MORGAN AND MORECAMBE OFFSHORE WIND FARMS: TRANSMISSION ASSETS

Applicants' Response to Deadline 5 submissions from Statutory Consultees and other organisations

Document Reference: S_D6_2
F01

22 October 2025

Figure 1.17a: Undefended 1% AEP fluvial event plus 20% climate change uplift

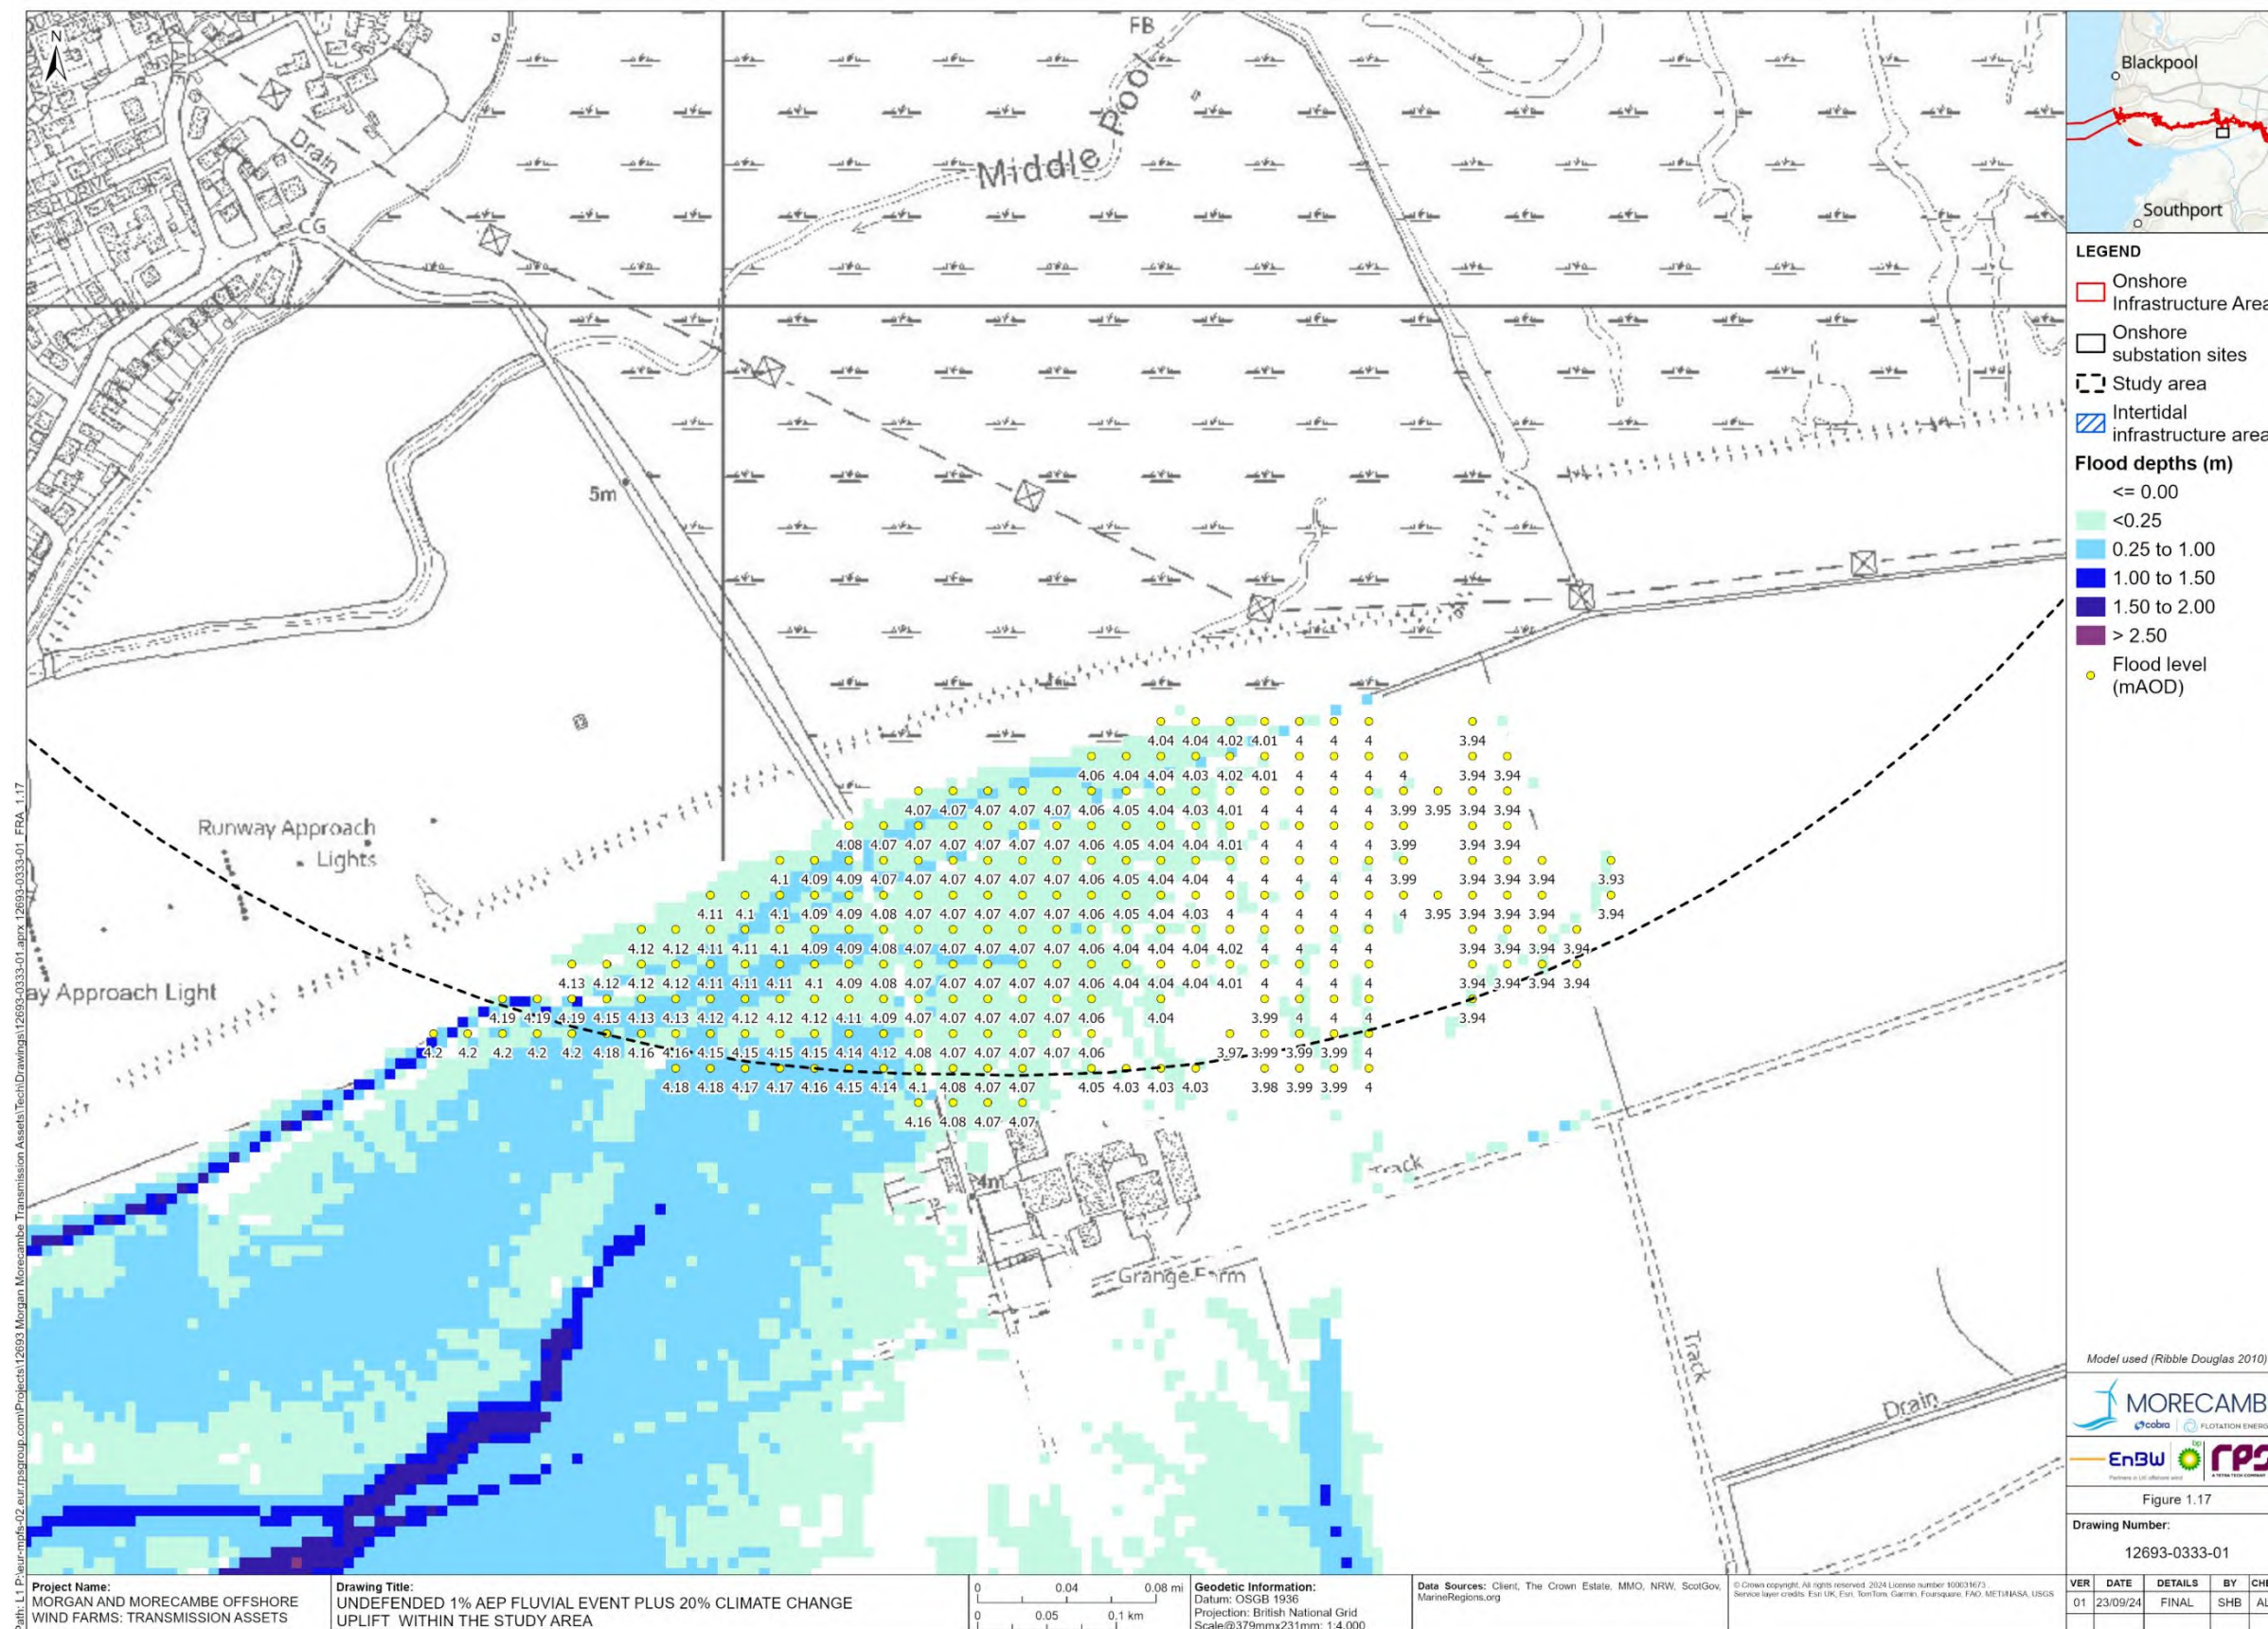
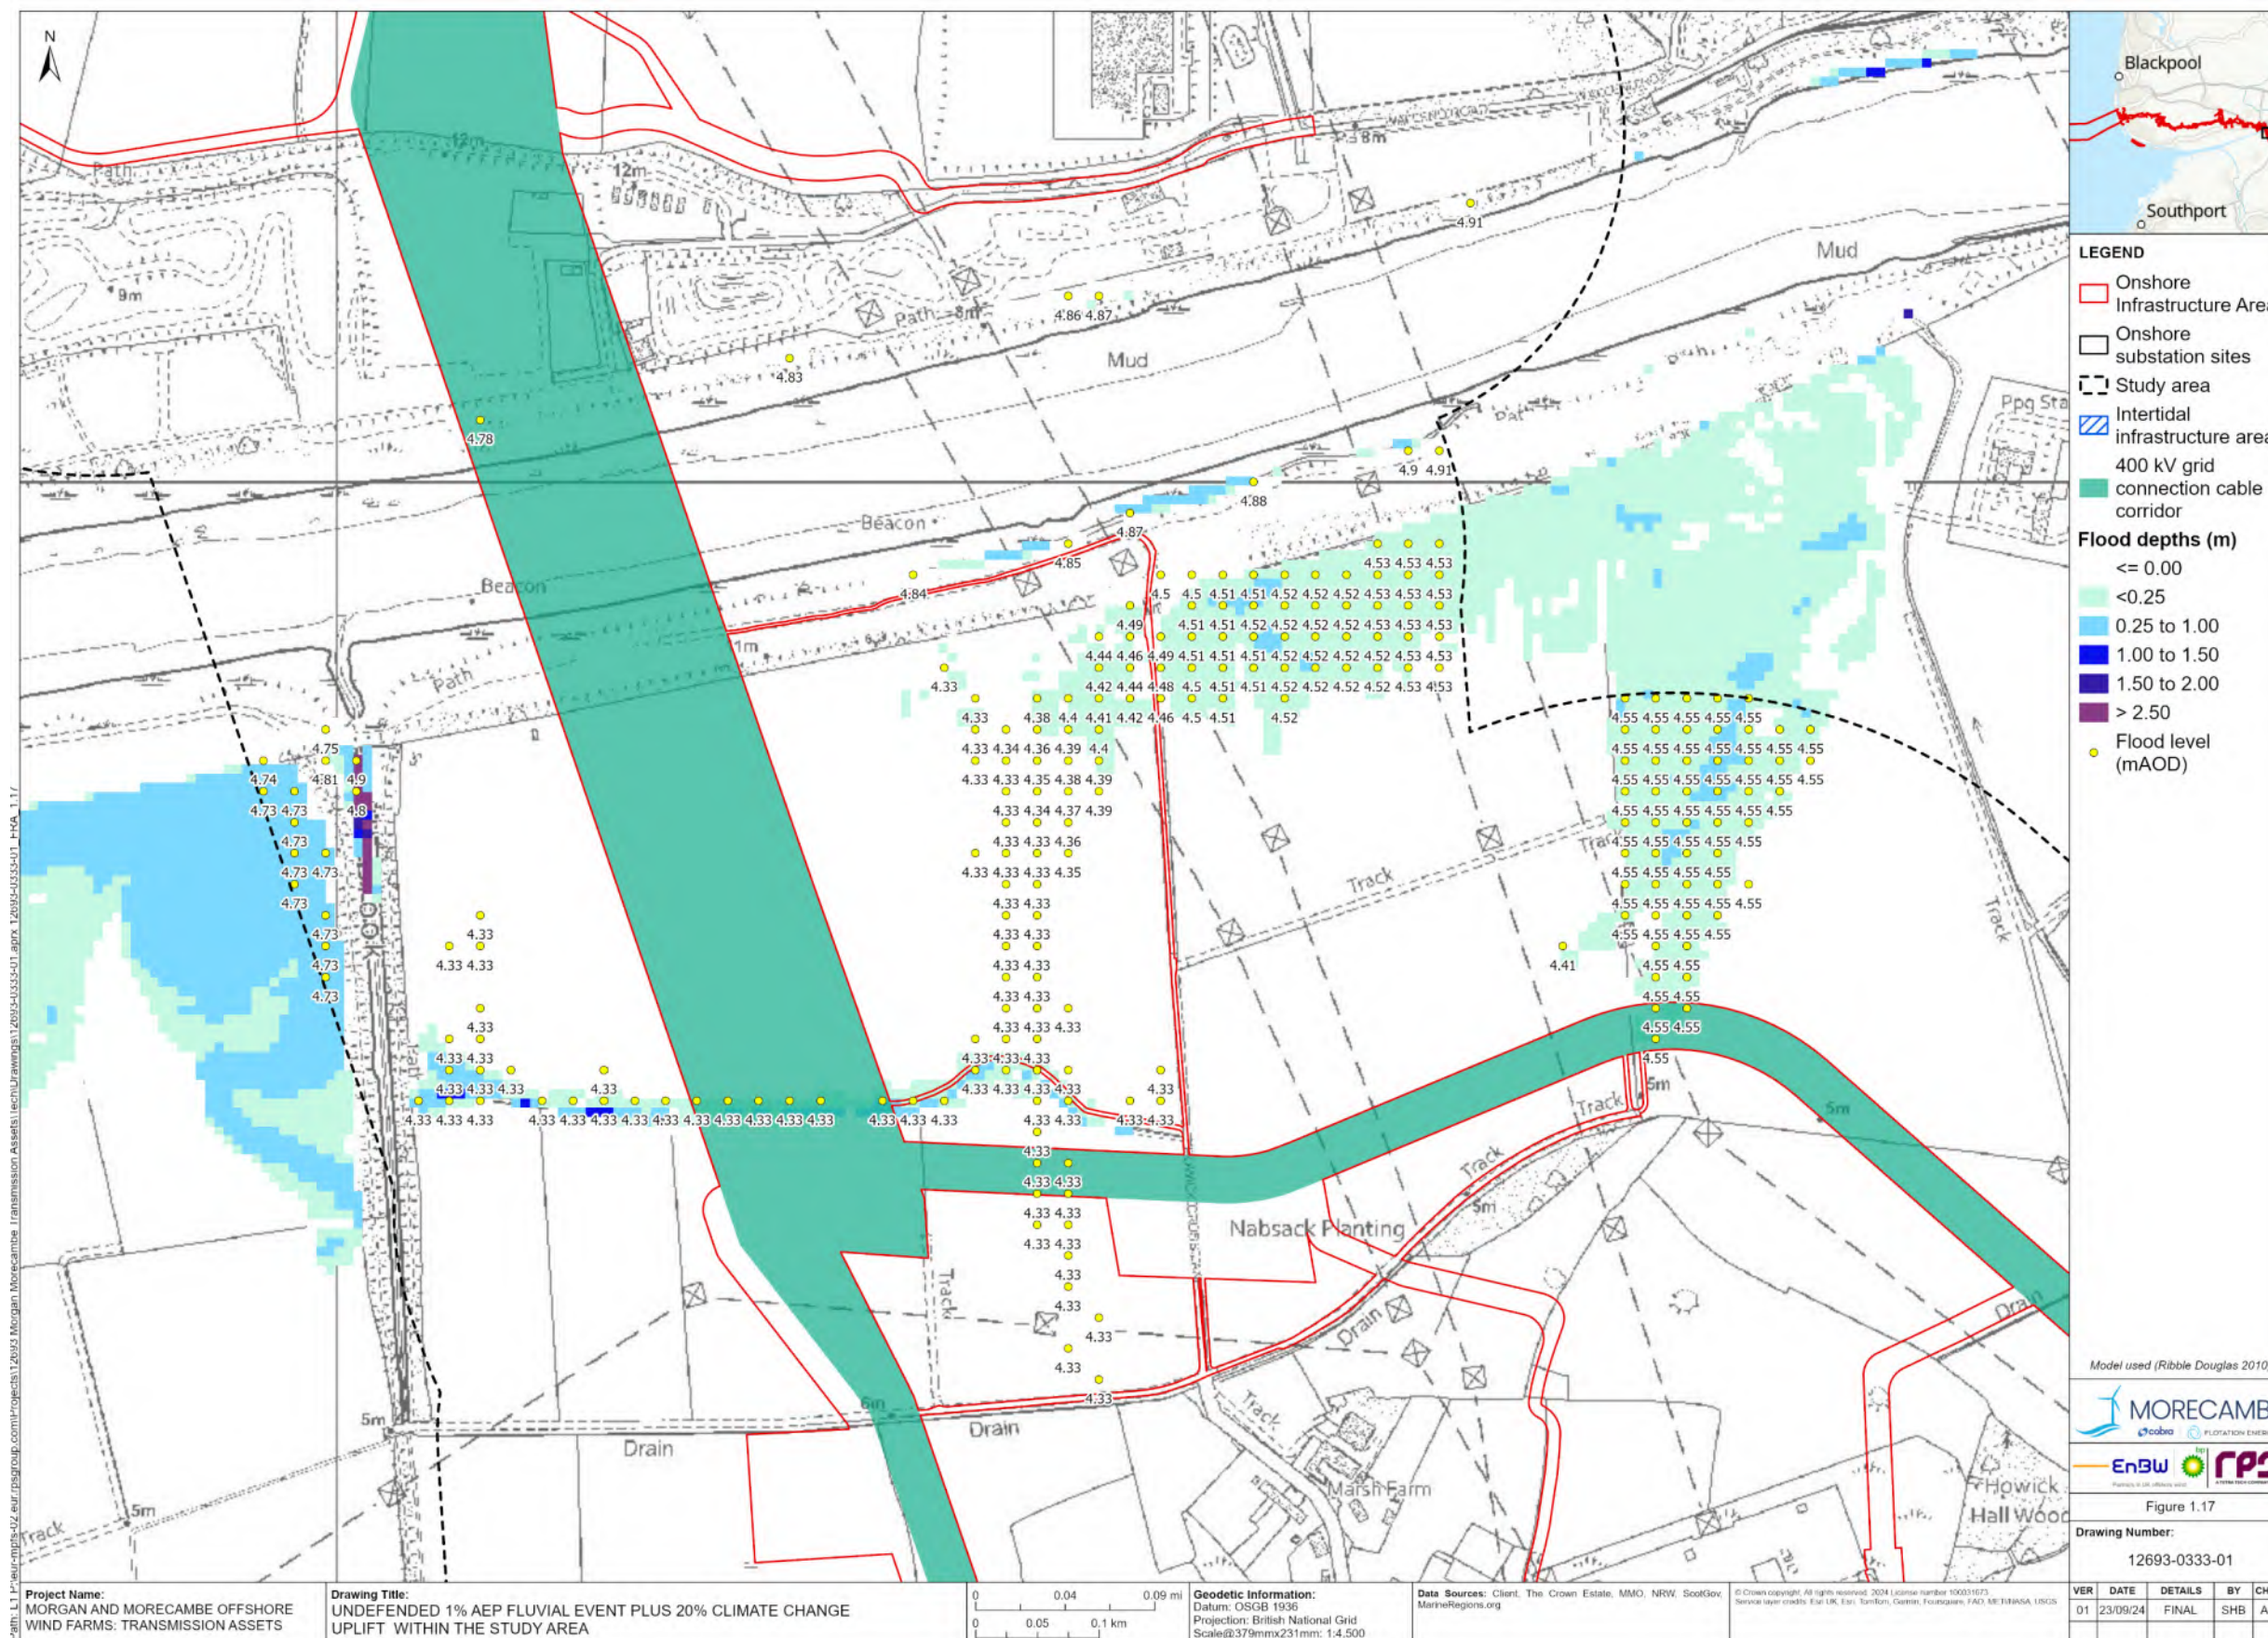
REP5-168	<p>Volume 3, Annex 2.3: Flood risk assessment - part 2</p>	<p>The Applicants note this comment and confirm that the discrepancy only appeared on the tracked version and therefore, no changes were required. The</p>

Reference	IP submission	Applicants' response
168.9	<p>Pages 163- 166</p> <p>Issue: Changing in titles and figure numbers appears to have resulted in a discrepancy between the new figure label in the report and the figure reference in the original title box of the drawing.</p> <p>Impact: This makes references somewhat problematic and confusing.</p> <p>Solution: Clerical error requiring correction</p>	<p>Applicants have ensured that all figure references and numbers are consistent. An updated version of volume 3, Annex 2.3: Flood risk assessment (F3.2.3/F03) has been submitted at Deadline 6.</p>
REP5-168 168.10	<p>Volume 3, Annex 2.3: Flood risk assessment part 3</p> <p>Issue: Like previous comments.</p> <p>Changing in titles and figure numbers appears to have resulted in a discrepancy between the new figure label in the report and the figure reference in the original title box of the drawing.</p> <p>e.g. Figure 1.23: Undefended 1% AEP fluvial event plus 20% climate change uplift on Page 199 is figure 1.17 in the drawing title box.</p> <p>Impact: This makes referencing somewhat problematic and confusing.</p> <p>Solution: Clerical error requiring correction</p>	<p>The Applicants note this comment and have updated all figure references and numbers where appropriate. An updated version of volume 3, Annex 2.3: Flood risk assessment (F3.2.3/F03) has been submitted at Deadline 6.</p>
